**Consultation Response from KC,
Highways Development Management****2026/91076 Builders Yard, The Old Brickworks, Top O' Th' Bank, Thurstonland, Huddersfield,
HD4 6UY****Demolition of existing building and erection of detached dwelling with ancillary works****Date Responded: 17 August 2026****Responding Officer: Sheila Henley****Responding Ref: 12-16/14****Recommendation: No objection subject to conditions for an evcp, surfacing and
driveway gradient.**

Plan ref: 206 2.002 G planning; 186-93-002 Proposed Swept Path

DRAWN BY	SCALE	1:100 @ A1
DATE	April 2026	DRAWING NO.
CHECKED	124/2/002	REVISION
		G

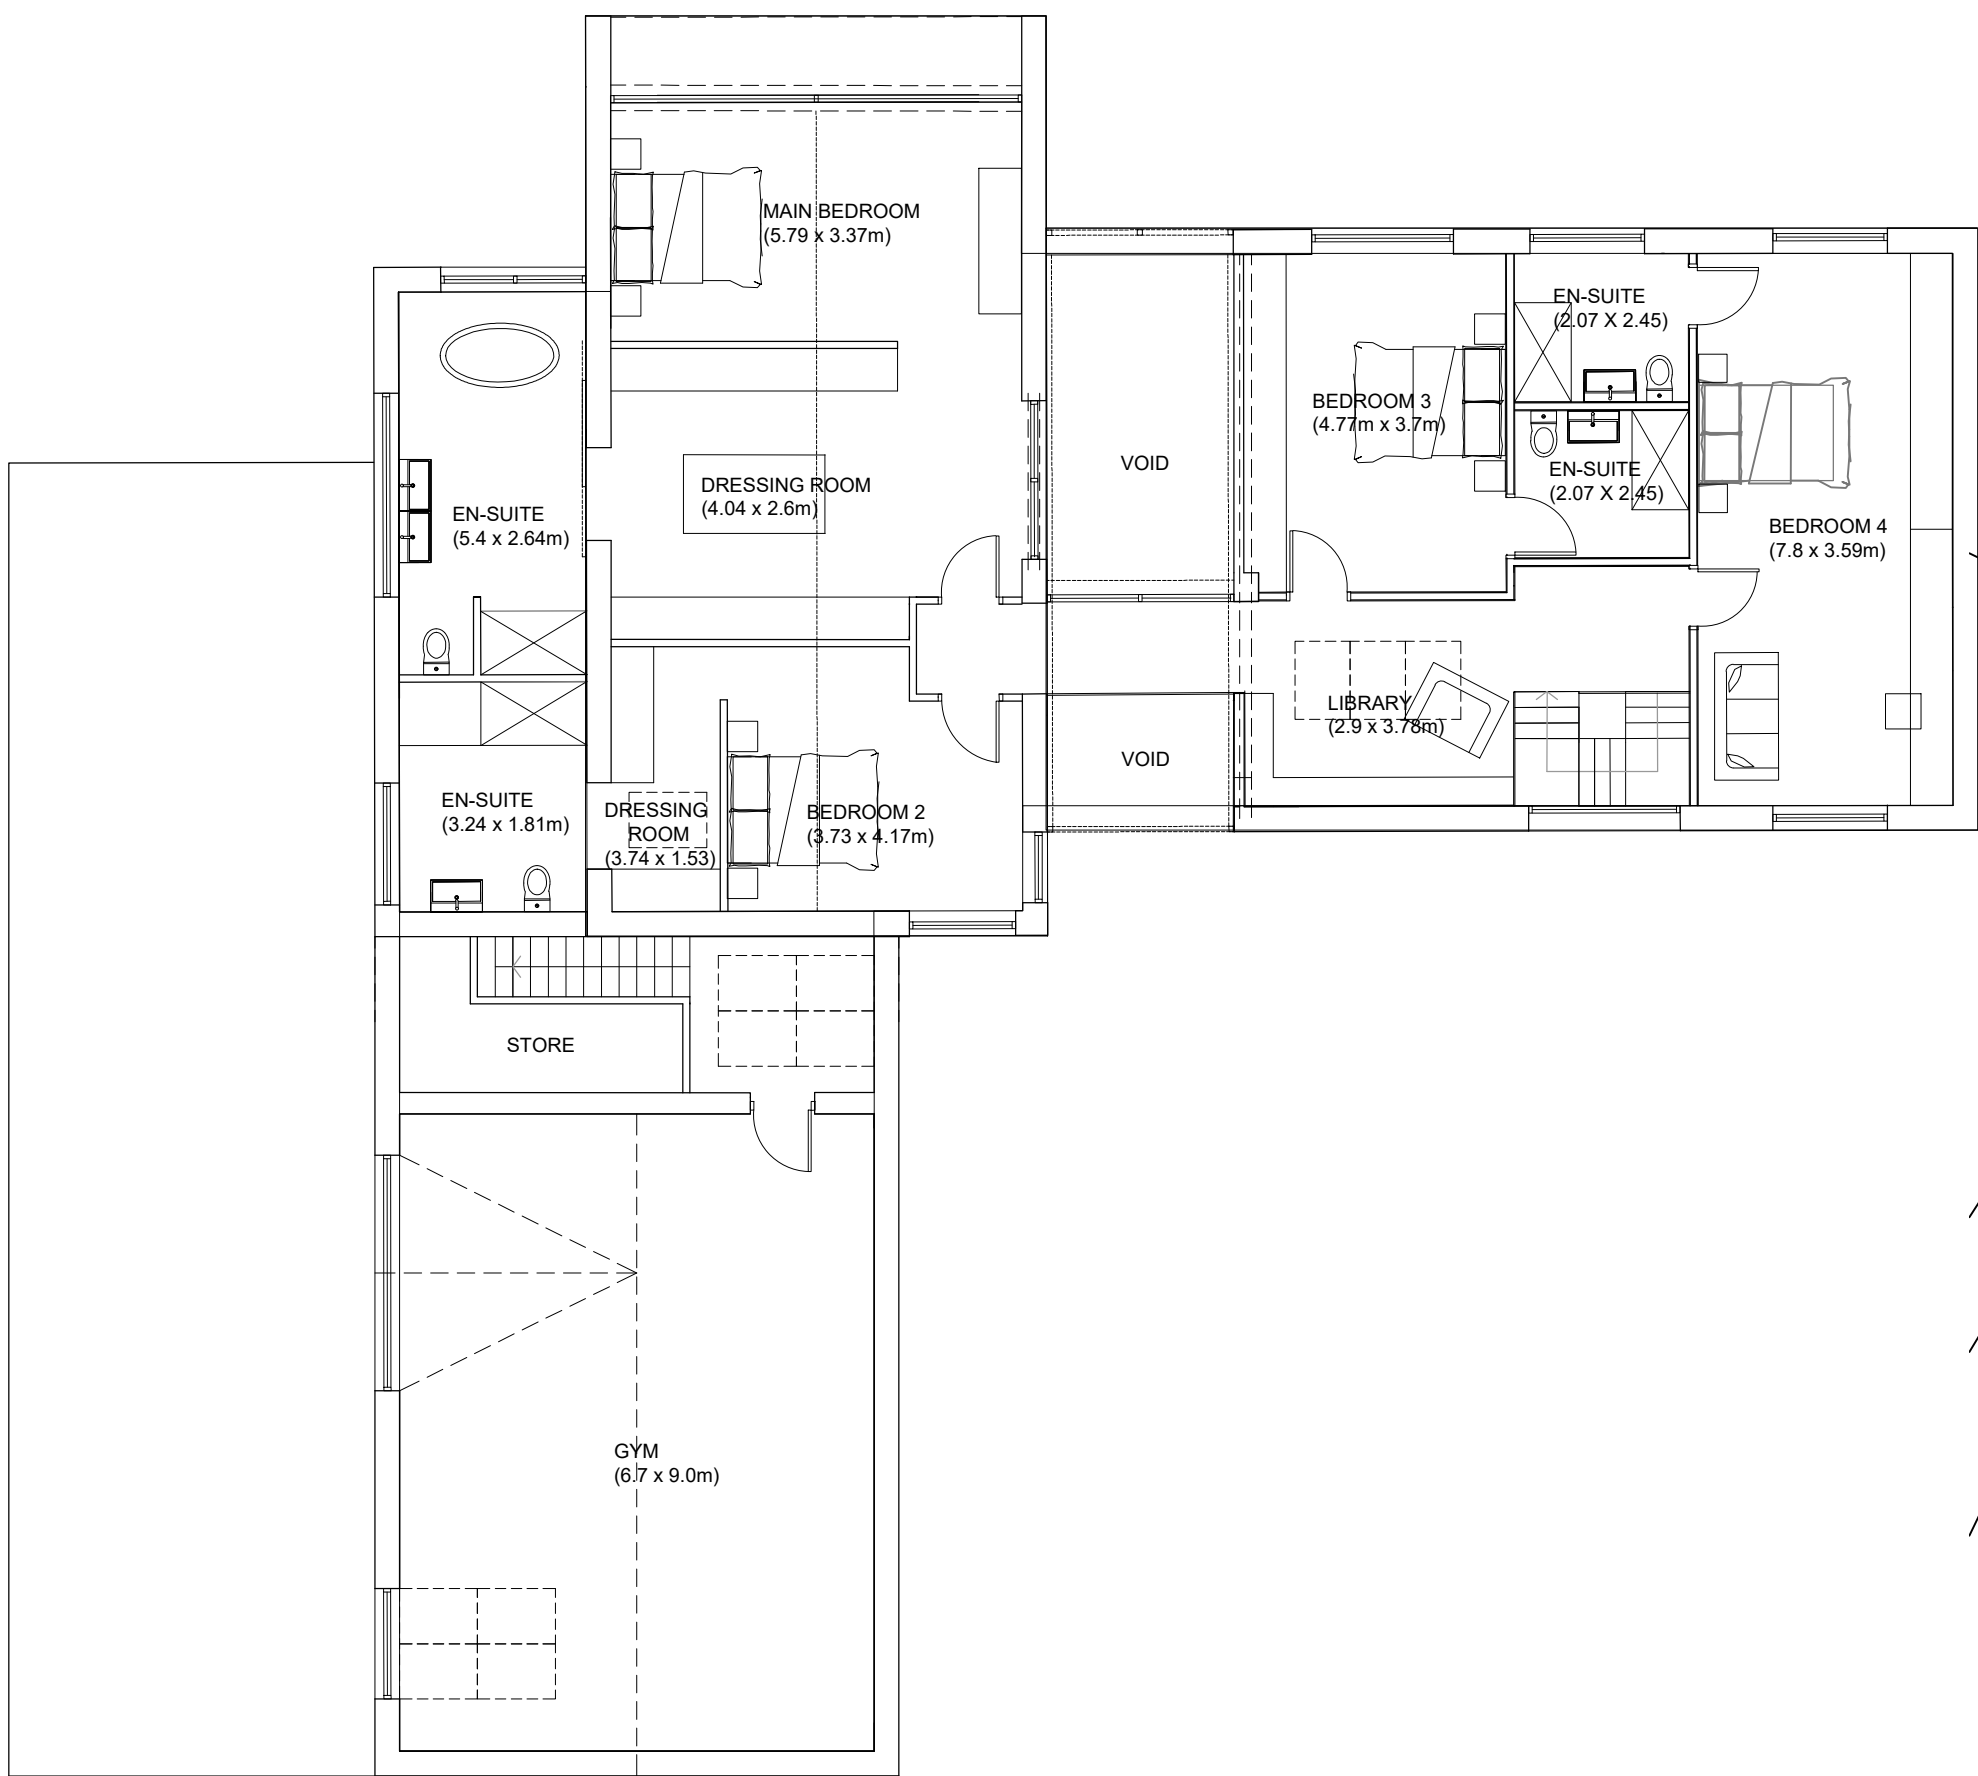
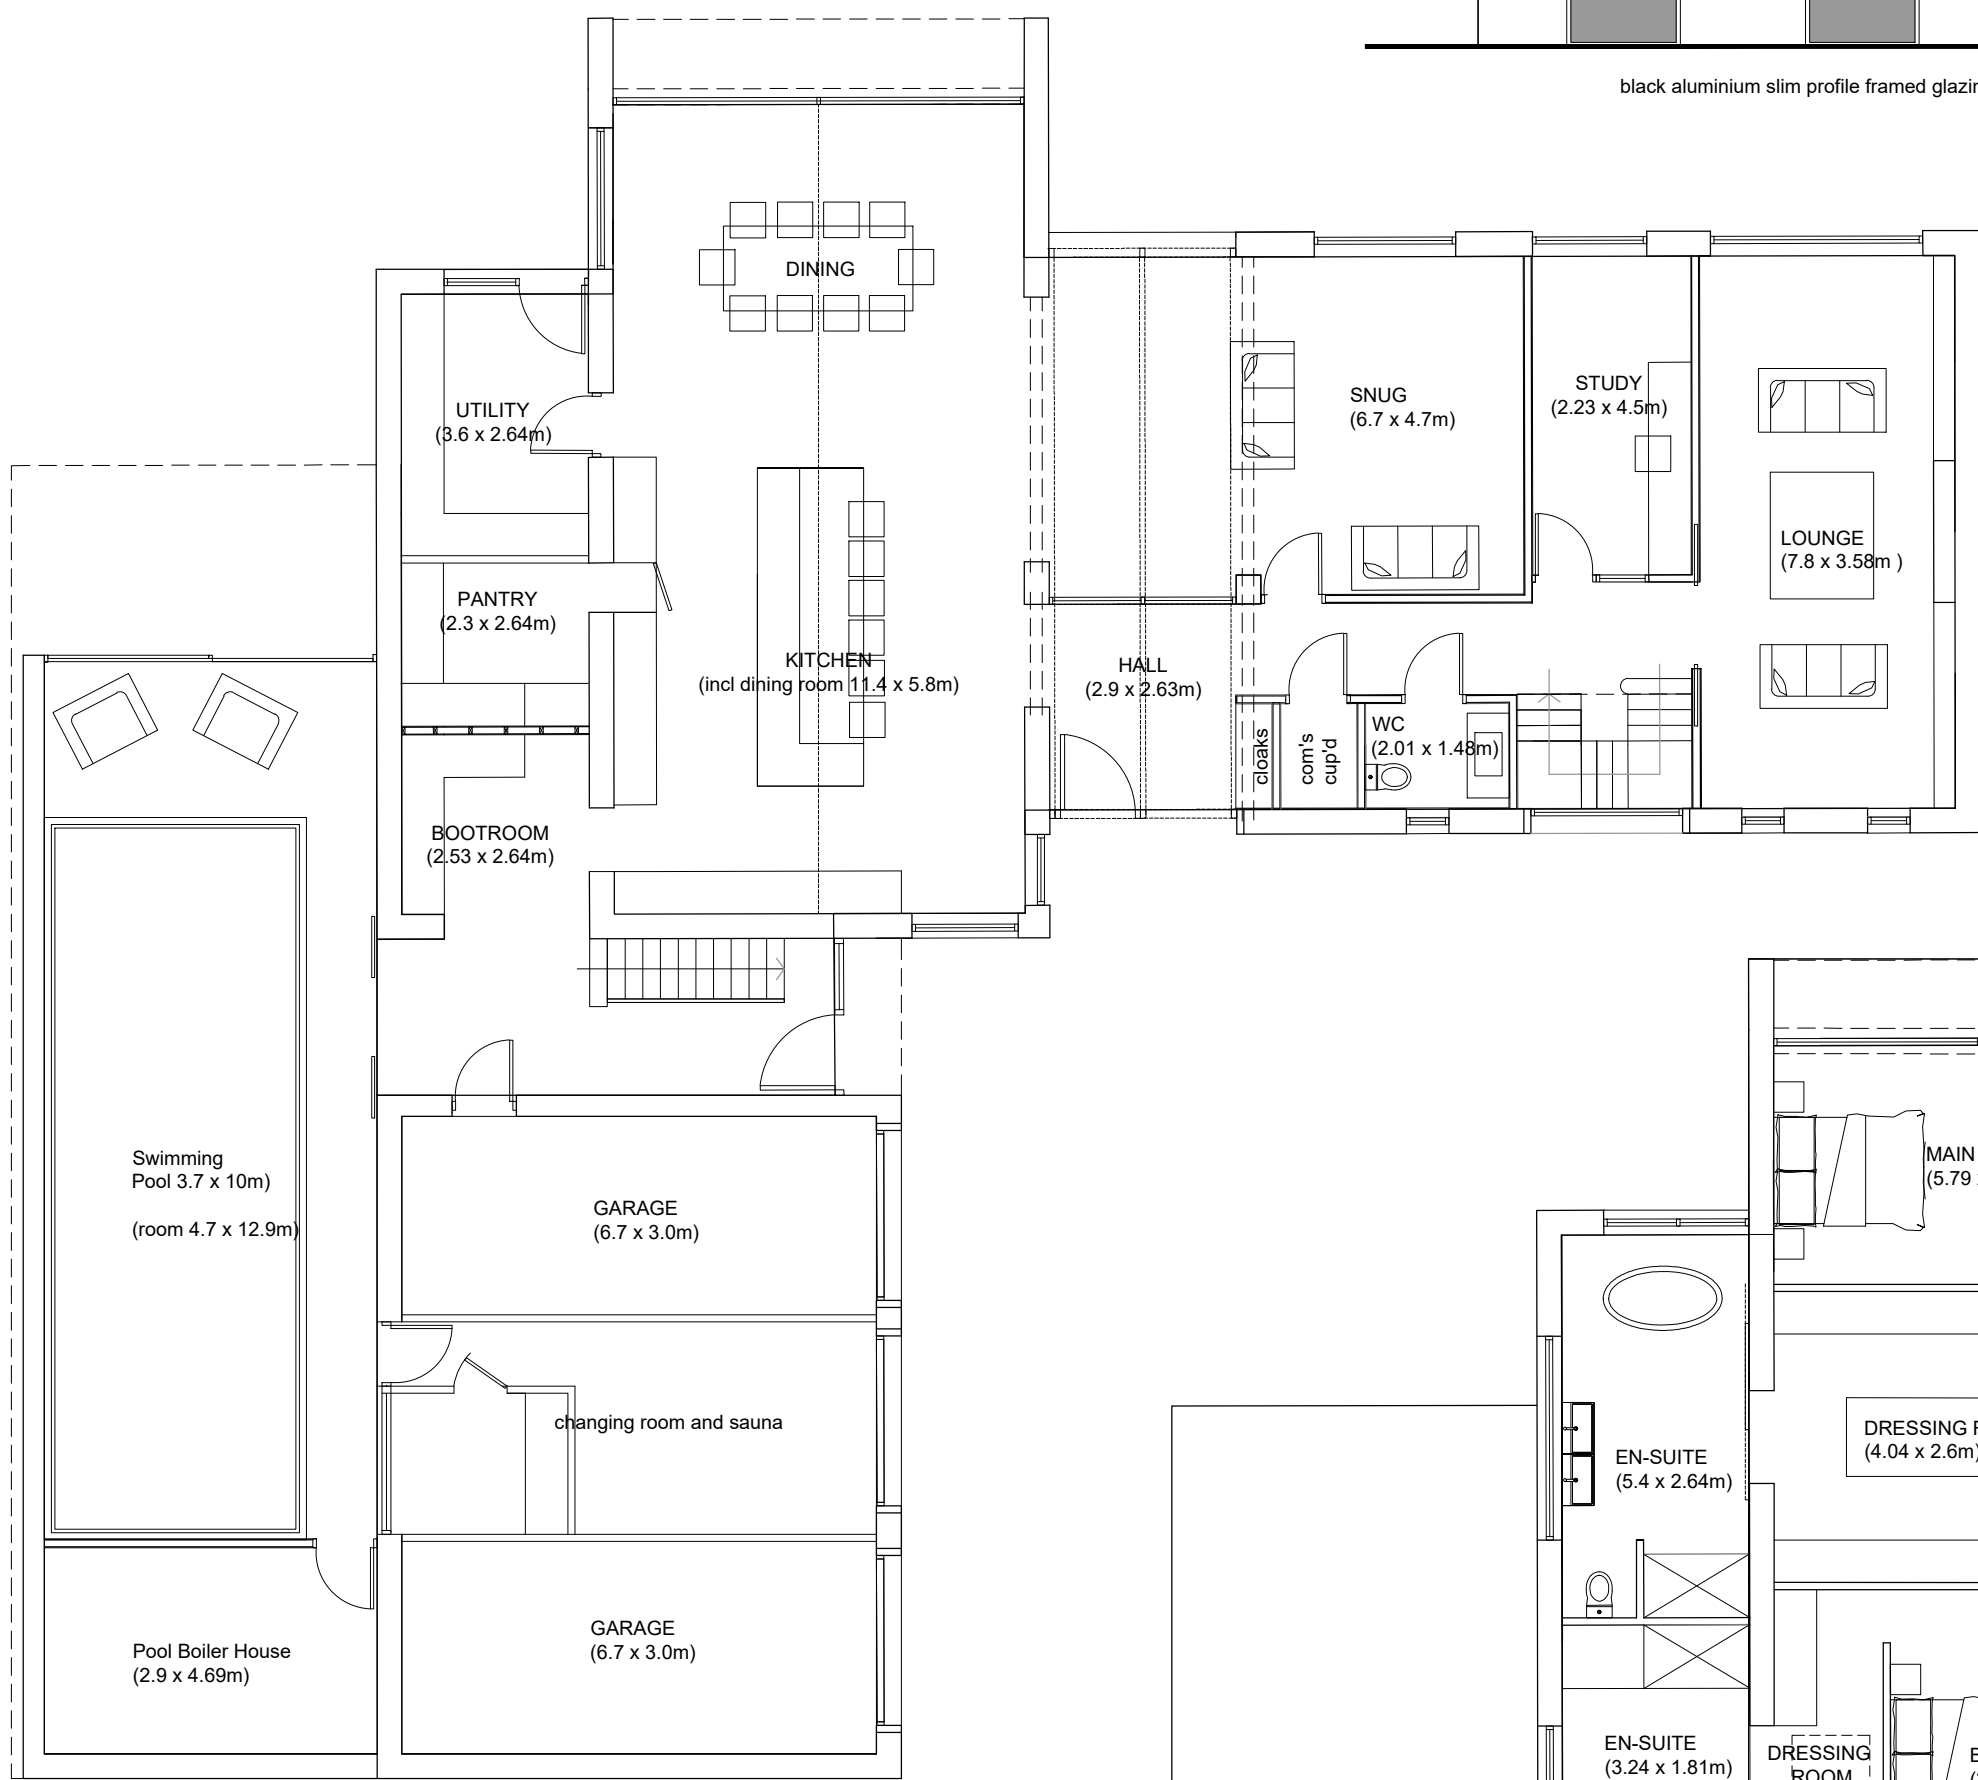
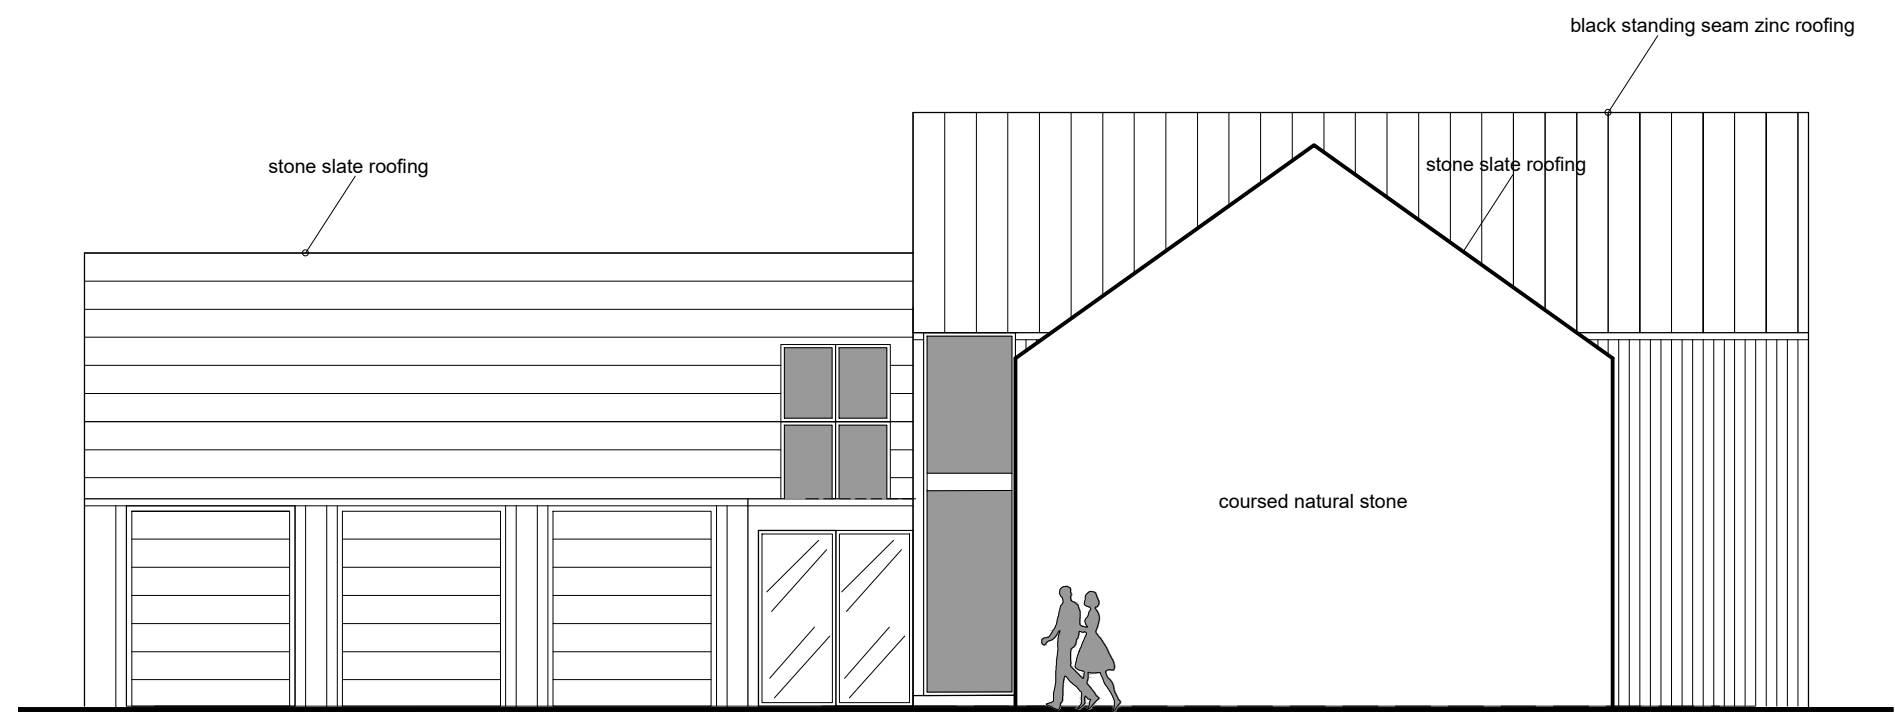
To support policy LP20, Active Travel objectives and encourage more choice, cycle parking could be provided within the garages to provide at least one spaces as desired under the Kirklees Highway Design Guide SPD or preferable to one space per bedroom under later guidance in LTN1/20.

An electric vehicle charging point will be necessary, preferably to be positioned in a garage to further encourage sustainable travel and lower emissions under policies LP20 and LP24.

The site is to be served from an unadopted section of Top O' Th' Bank which serves seven dwellings and a Joiners' shop and commercial usage of the builder's yard. There would be a new driveway access shown as ungated, but of a width suitable for two-way movements and shared use between pedestrians and vehicles. This section of the street is unsuitable for adoption and would remain privately managed. It is suggested that the access is gated and that these open inwards

Within the site there is to be a new driveway leading to the building entrances, including a garaging area with two singles with an internal size of 6.7 x 3m. The new driveway is of ample size to allow for external parking and turning as well as shared use between pedestrians and vehicles. Its gradient should not be greater than 1 in 12.

The garages too are larger, internally, than suggested in the KHDG SPD of 6 x 3m and would be suitable to count towards car parking and the storage of cycles and other items.

Any new surfacing should be of a porous material or a surface water drainage scheme provided.

- a) Electric Vehicle Charging Point: Development shall not be occupied until an Electric Vehicle Charging Point has been provided in accordance with a scheme that shall have been submitted to and approved in writing by the Local Planning Authority. The approved facilities shall thereafter be retained for the lifetime of the development.

- b) Surfacing: Development shall not be occupied until all areas shown on the approved plans to be used by pedestrians and vehicles on the approved plans have been laid out, surfaced in a porous material or drained, such that loose materials and surface water does not discharge or transfer onto the adjacent street, and shall thereafter be retained and maintained for the lifetime of the development.

- c) Maximum Driveway Gradient: The gradient of the driveway shall not exceed 1 in 12.5 (8%).
